Appeal Decision

Appeal Ref: APP/R5510/W/22/3296099

128D & 130D Manor Way, Ruislip HA4 8HR, 509980.0, 187366.0

The main issue is whether or not the appeal scheme would provide adequate living conditions for future occupiers with particular regards to outlook, noise and privacy.

Proposed floor plans

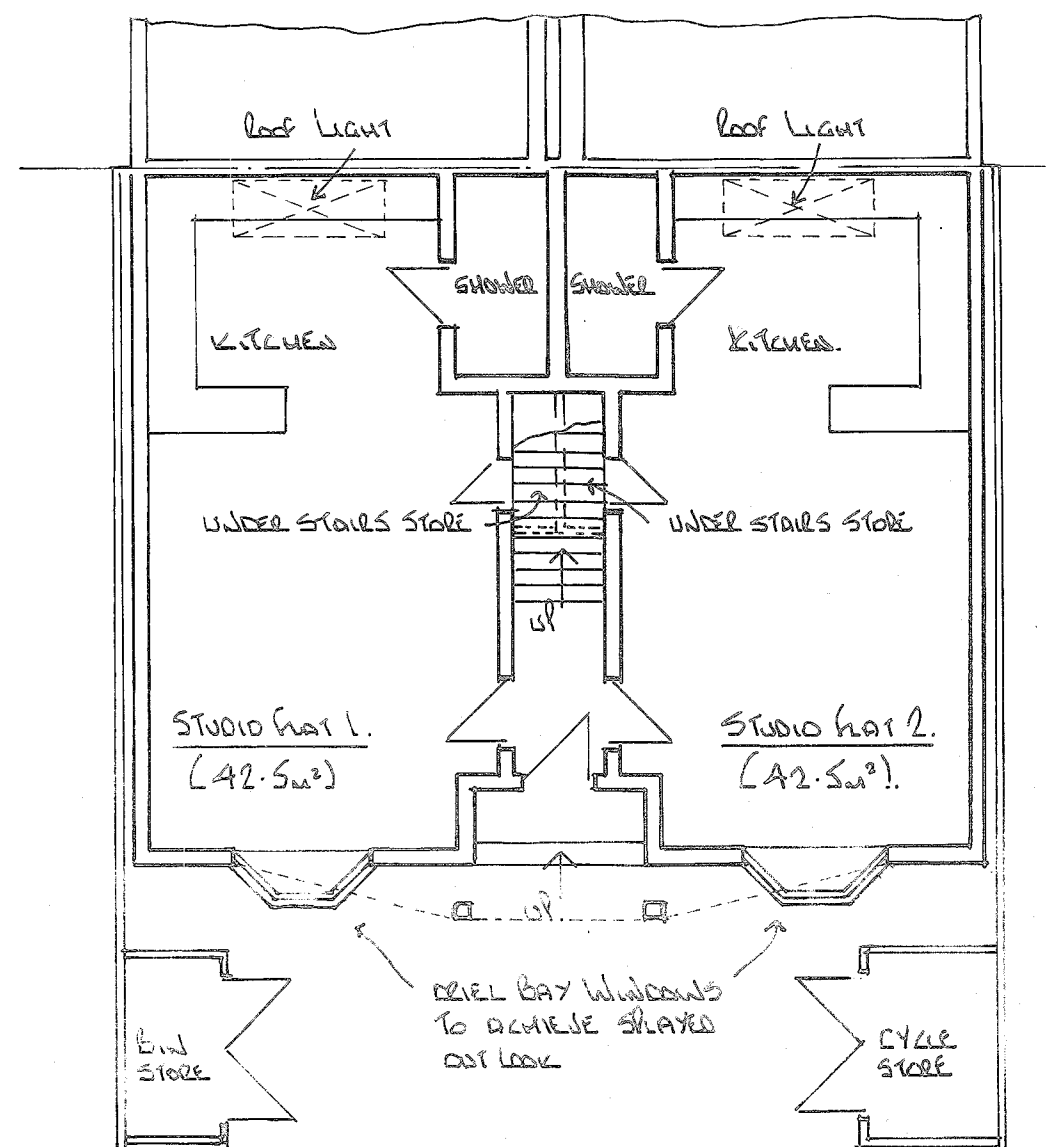
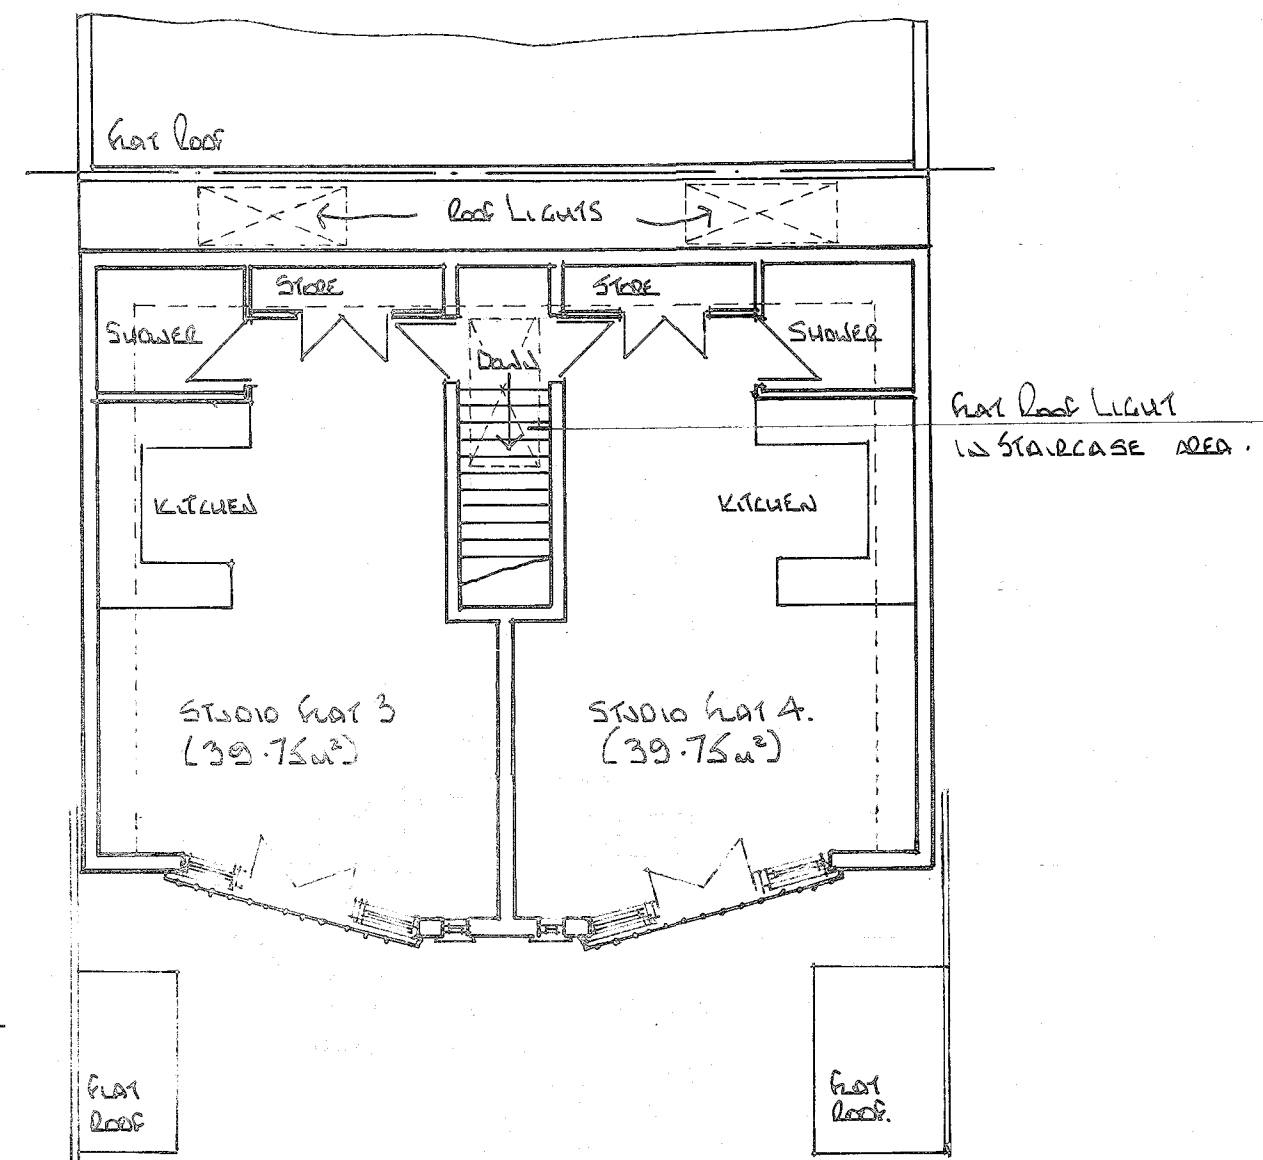
3. The appeal scheme appears on the submitted plans as an almost total rebuilding of the ground floor flats (referred to as 1 and 2 on the submitted plans) to create significantly deeper and wider flats, including the incorporation of oriel bay windows, and stair access to the proposed first floor flats (referred to as 3 and 4 on the submitted plans) that incorporate large, angled windows to southeast elevation. The appellant's statement of case also refers to the removal of the boundary wall to the service road.

7. The access to the flats is directly from the service road to the front of the proposed flats. In the absence of any definition to the boundary or landscaping in front of the flats any user of the service road, residents or visitors would pass directly in front of and in close proximity to the windows of the ground floor of the property. It is my planning judgement that this would result in noise and disturbance and a loss of privacy that would negatively impact on the living conditions of the occupiers of the ground floor flats.

8. Turning to the first-floor flats, future occupiers would benefit to a degree from the angled large windows and an outlook unobstructed by the bin and cycle store. Nonetheless the outlook for the occupiers of flat 4 will be dominated by blank elevation of 42 Windmill Hill, situated in close proximity. It is not at dispute between the parties that the outlook for the future occupiers of flat 3 is acceptable and based on the evidence before me I find no substantive reason to disagree.

Proposed Elevations

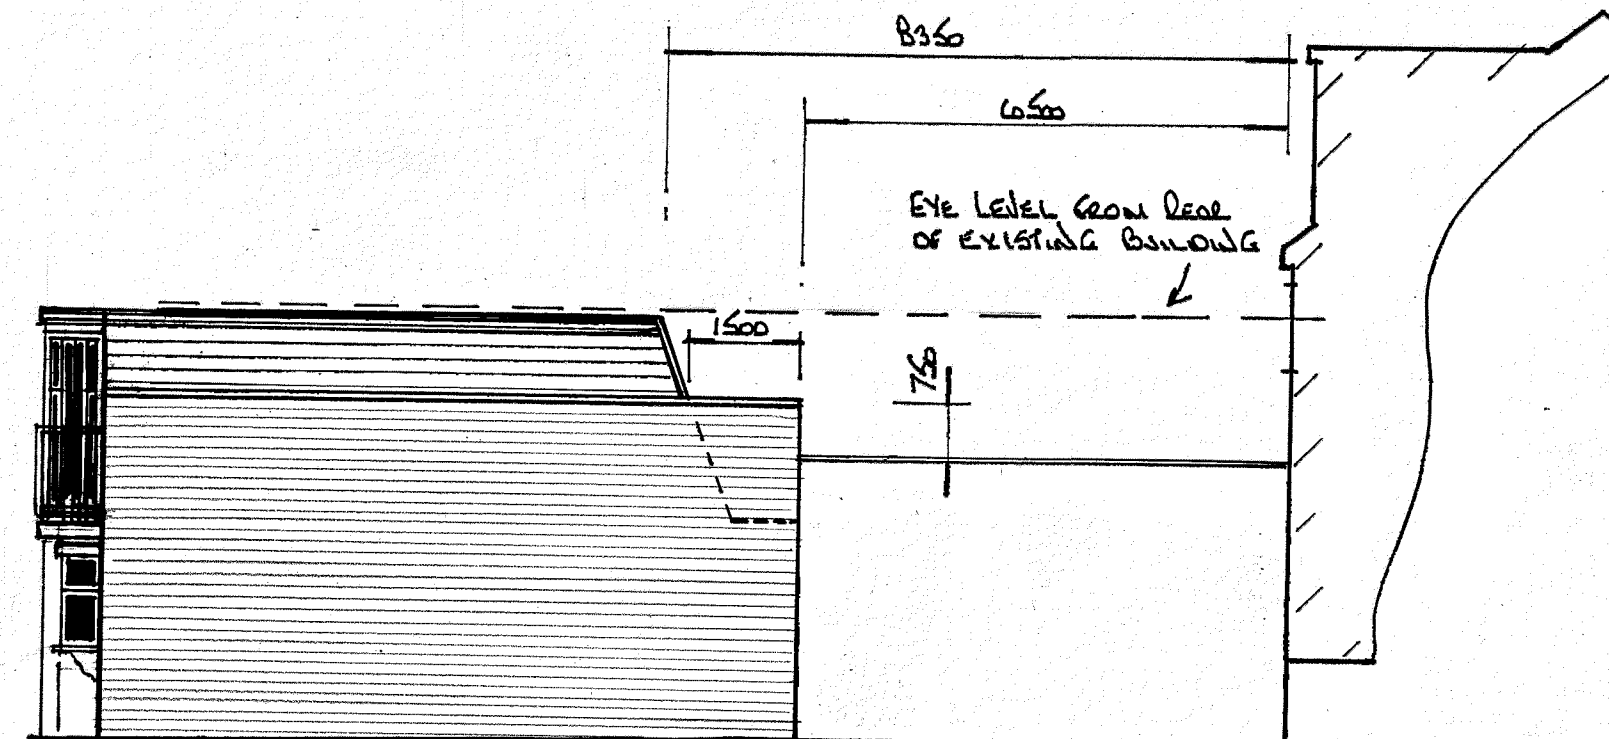
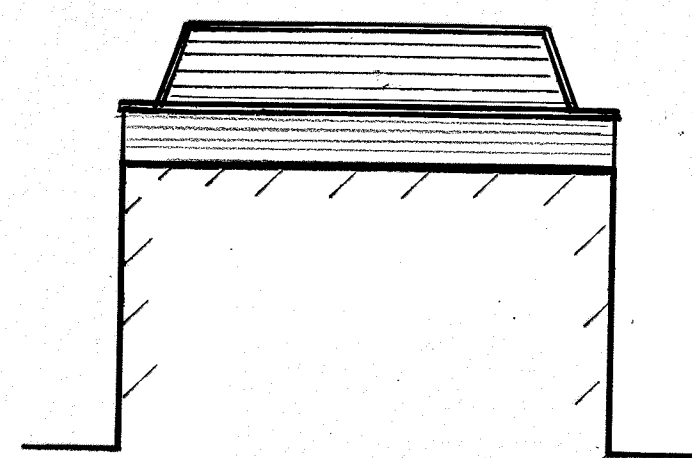
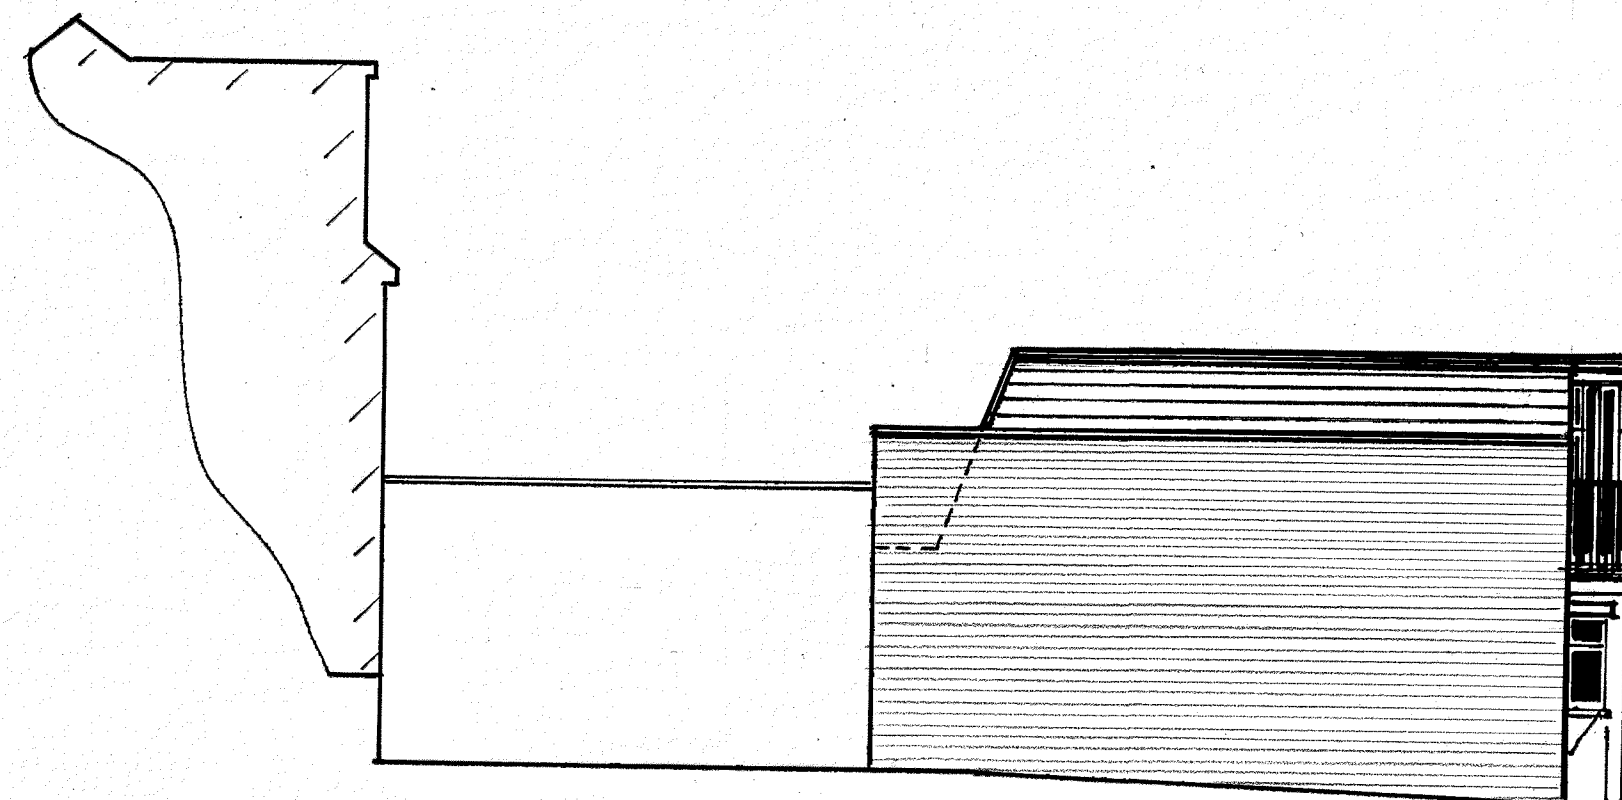
5. The appellant's statement of case details that the ground floor oriel bay windows and removal of the boundary wall have been introduced into the

appeal scheme with the intention of improving the outlook for the future occupiers.

6. However, the submitted elevation plans clearly show that the windows would be partially obscured by and in close proximity to the proposed bin and cycle stores. I saw at the site visit that as a result of the proximity of the proposed ground floor flats to the service road and consequently the blank elevation of the adjacent building, the removal of the boundary wall would not meaningfully improve the outlook for the future occupiers of the ground floor flats.
